Planning Application Reference No.: 3/2025/0612

Address of Development: The Palace,
Market Place,
Longridge
PR3 3RR

PROPOSED CYCLE STORE PLAN
Scale 1:50

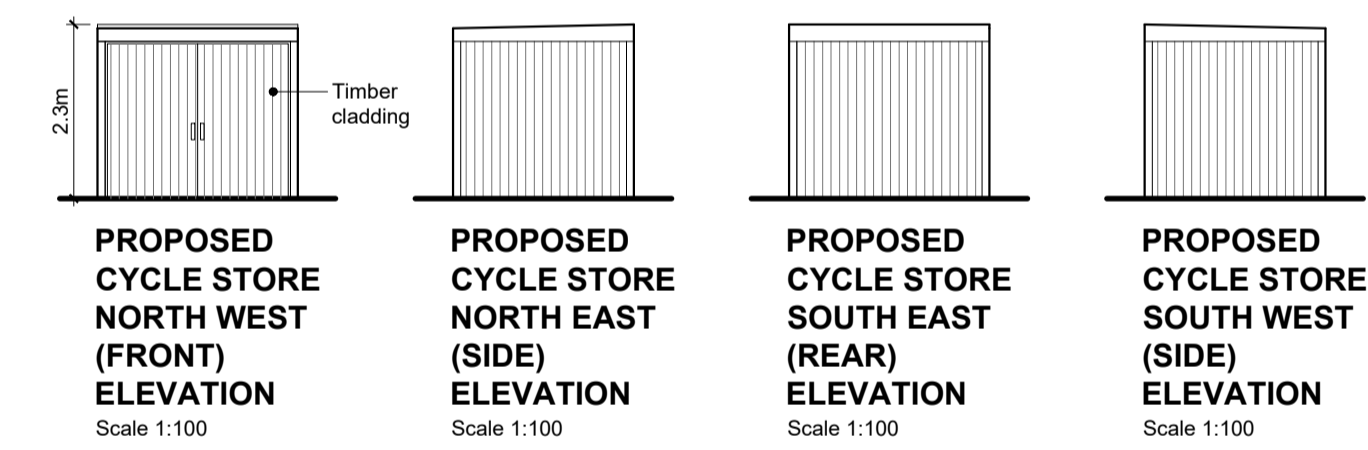
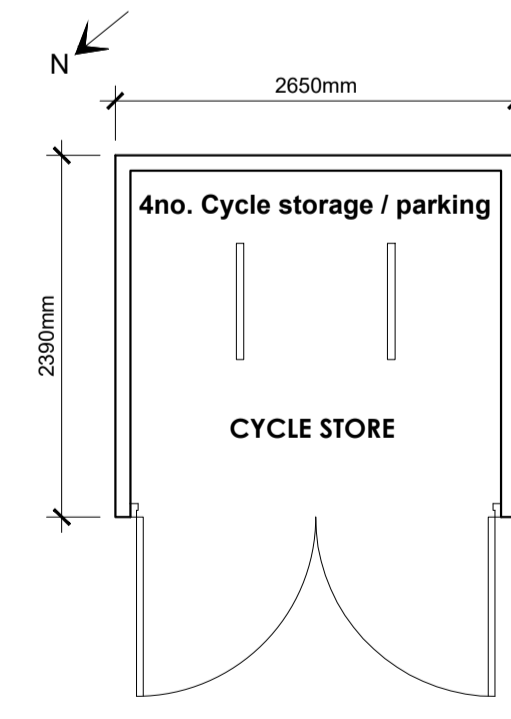
Comments: Having looked at the plan we have no objections in the proposals but would kindly ask, why there is a need for a cycle store, as the children will be accompanied by adults. Also can you ask the applicant if they could advise us of numbers of staff and parking for them as well as for the customers(children and parent) as Market Place is already a busy main road, and the rear of the cinema has a limited access via Brewery Street for Fire appliances and ambulances, perhaps a travel plan would help to alleviate our concerns, or highlight them further
